File: SF17/26824
Job ID: DOC17/316786
Your Ref: SSD 8126

RE: Heritage Council comments on Redevelopment of UNSW Cliffbrook Campus – Notice of Exhibition. (SSD 8126)

An Environmental Impact Statement (EIS) prepared by Urbis Pty Ltd, dated May 2017, including appendices: Conservation Management Plan (CMP 2017), dated April 2017 and a Heritage Impact Statement (HIS), dated 5 May 2017, both prepared by Weir Phillips and a Historical Archaeological Assessment, dated 3 March 2017 prepared by MDCA, has been reviewed and the following the following comments are provided:

title  
**General Arrangement Plans**  
**Heritage Refurbishment**

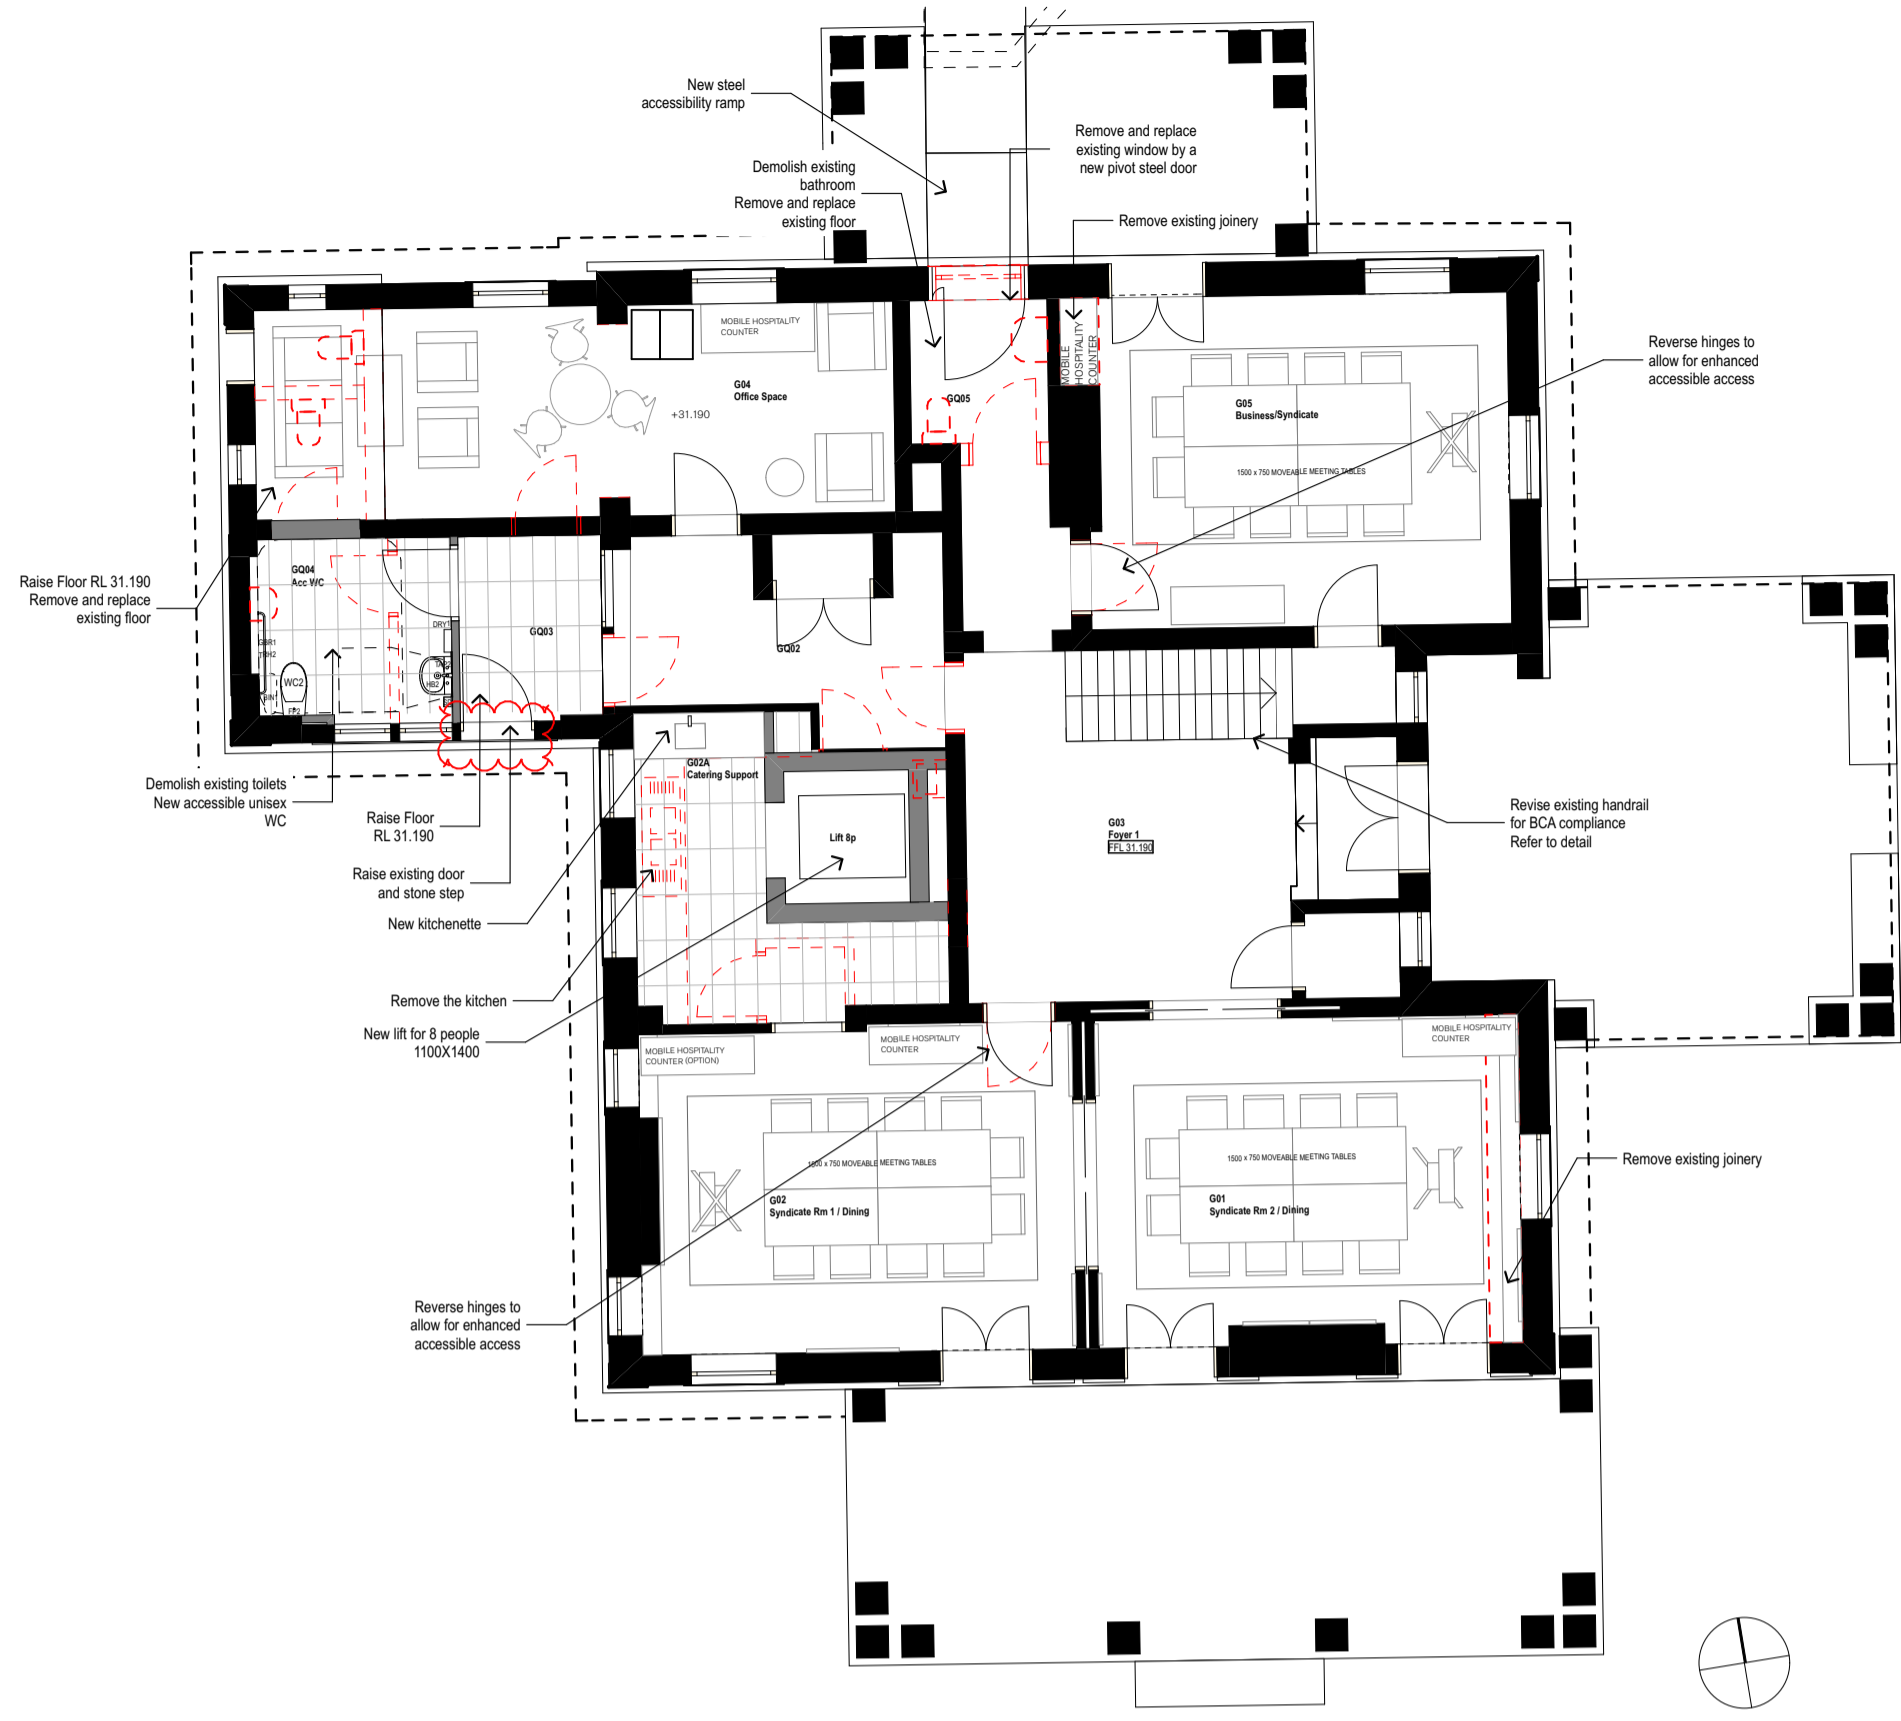
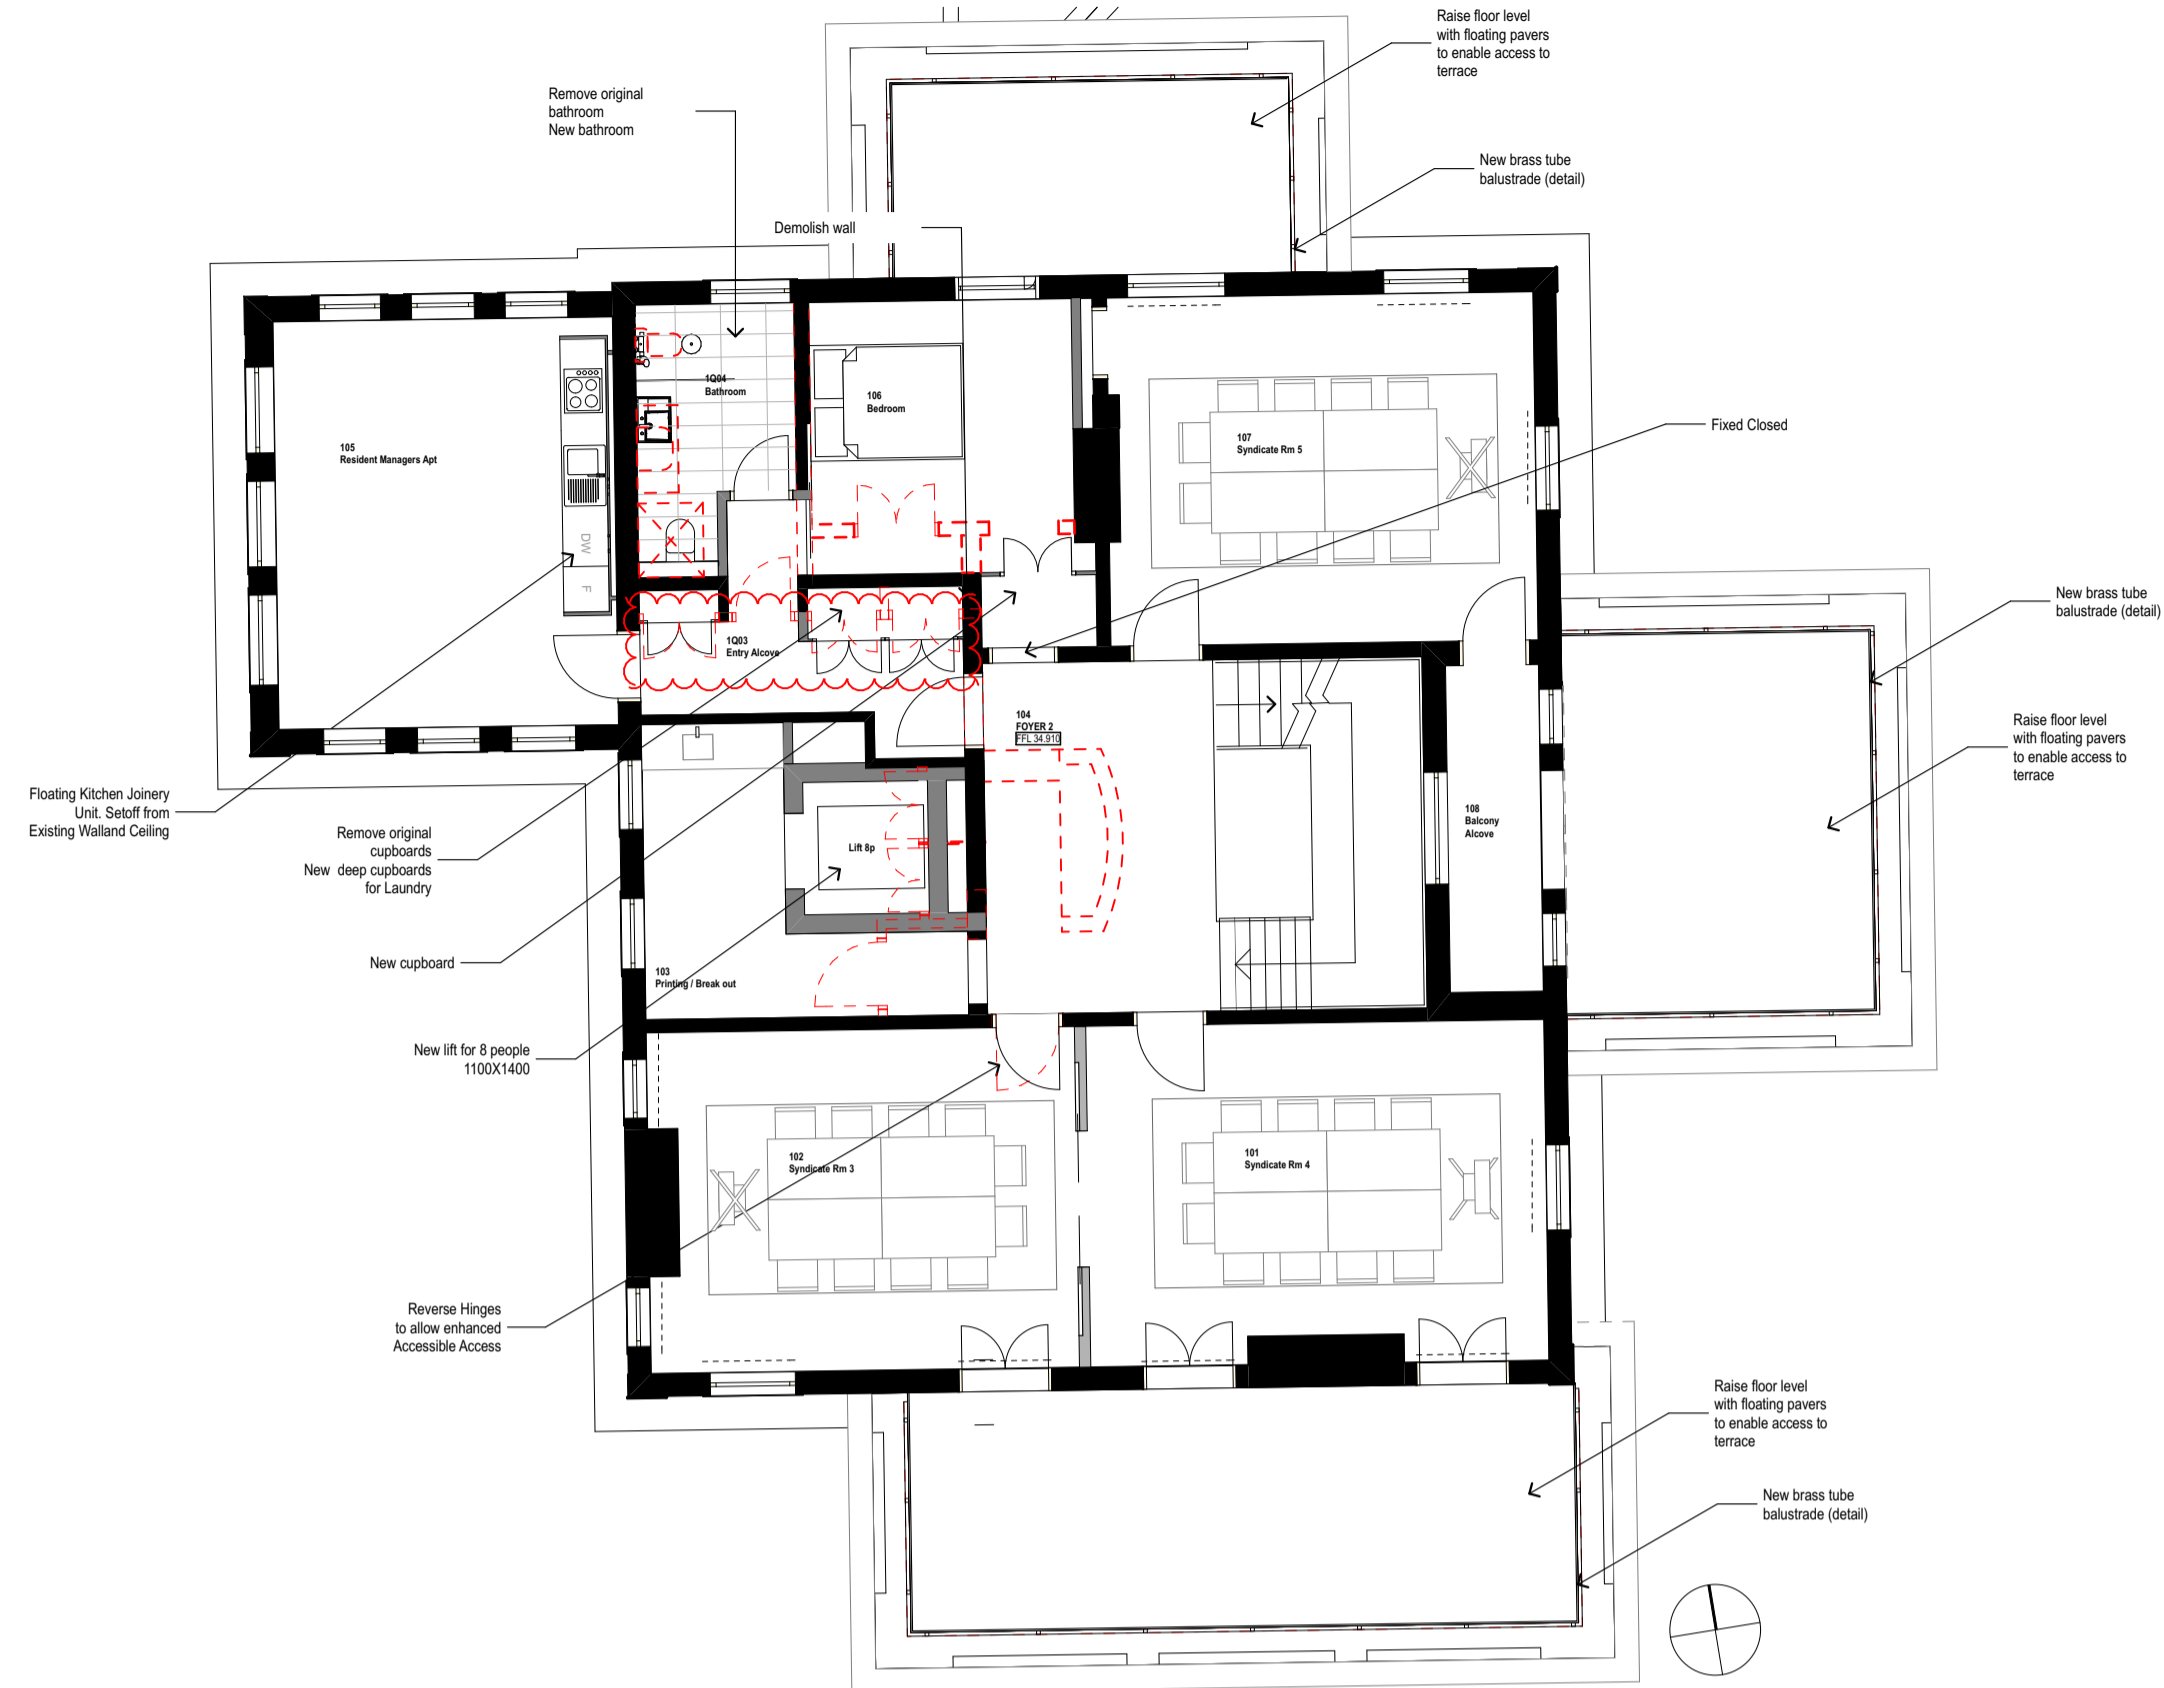
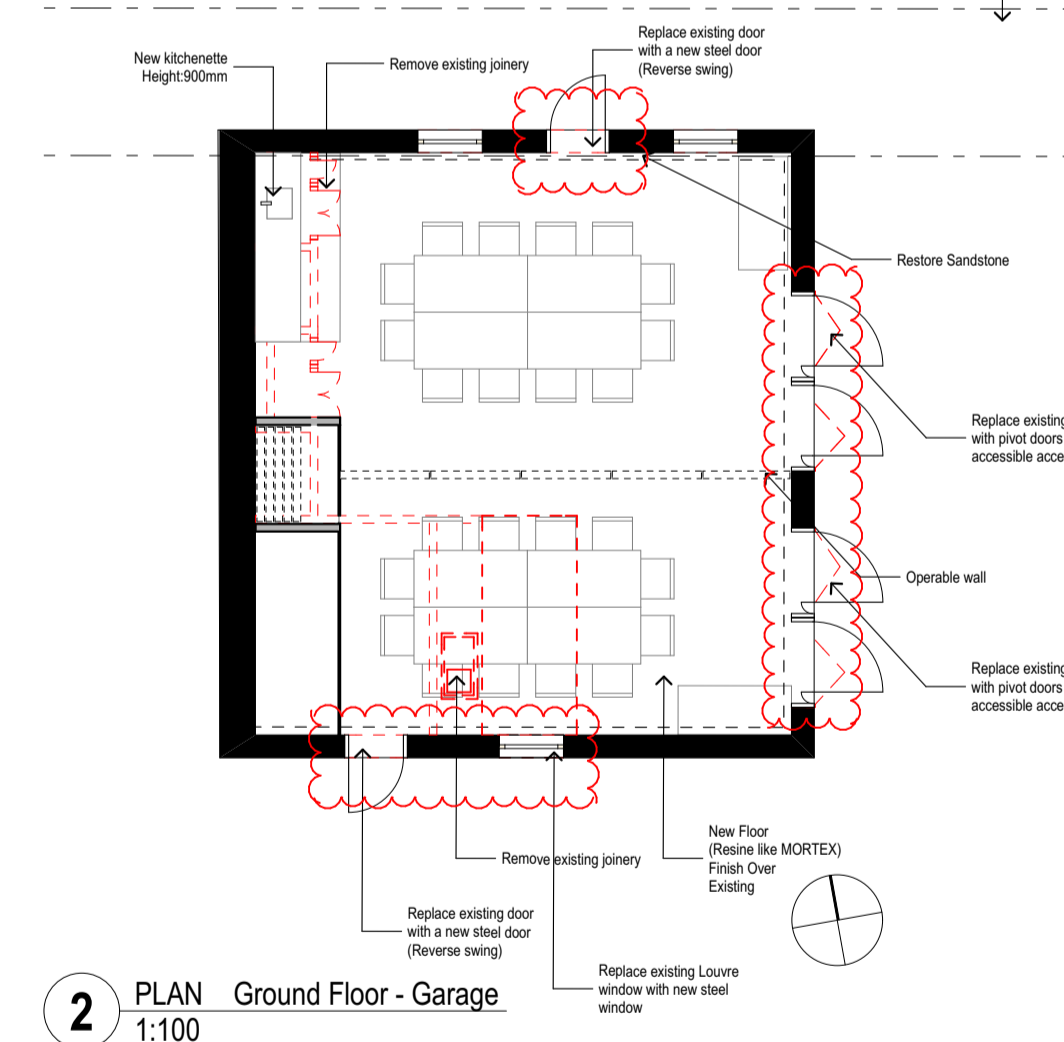
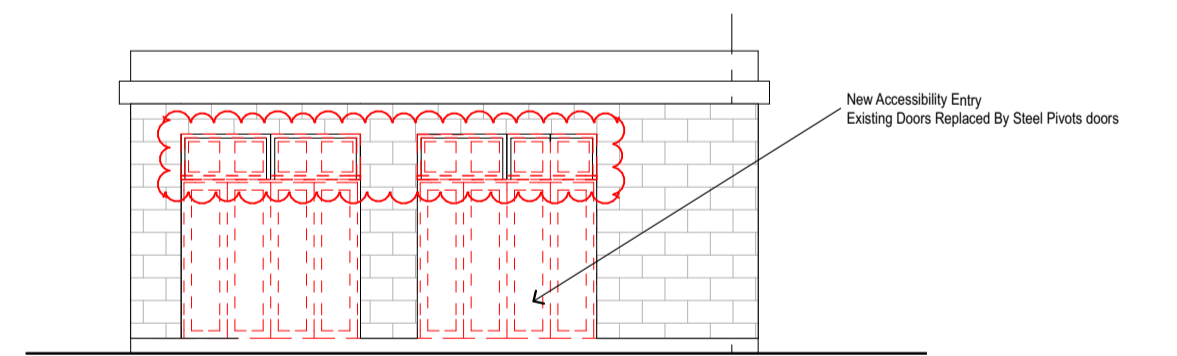
- The alterations to the terraces will not impact significant fabric, the pipe rail and tiling is recent and ranked 'D'- neutral in the HIS. It is suggested that existing fixings to be reused to install new BCA compliant balustrade required to enable access to terraces.

- The removal of the multi-paned window from the ground floor of the north elevation which is original fabric ranked 'A' exceptional unfortunate. However, it is noted that: several options were explored to provide an accessible entrance; the proposed location is within the northern porch on the least prominent elevation of the building; the steel entry platform will be reversible; and the intervention will be clearly detailed as new works while maintaining the width and rhythm of the pattern of fenestration and the sandstone lintel will remain in place. Additionally, no internal walls are required to be removed to provide the proposed access.

- If the proposed removal of the multipaned window is approved, the window should be required to be retained on site and possibly used either in another part of the building or for interpretation purposes.
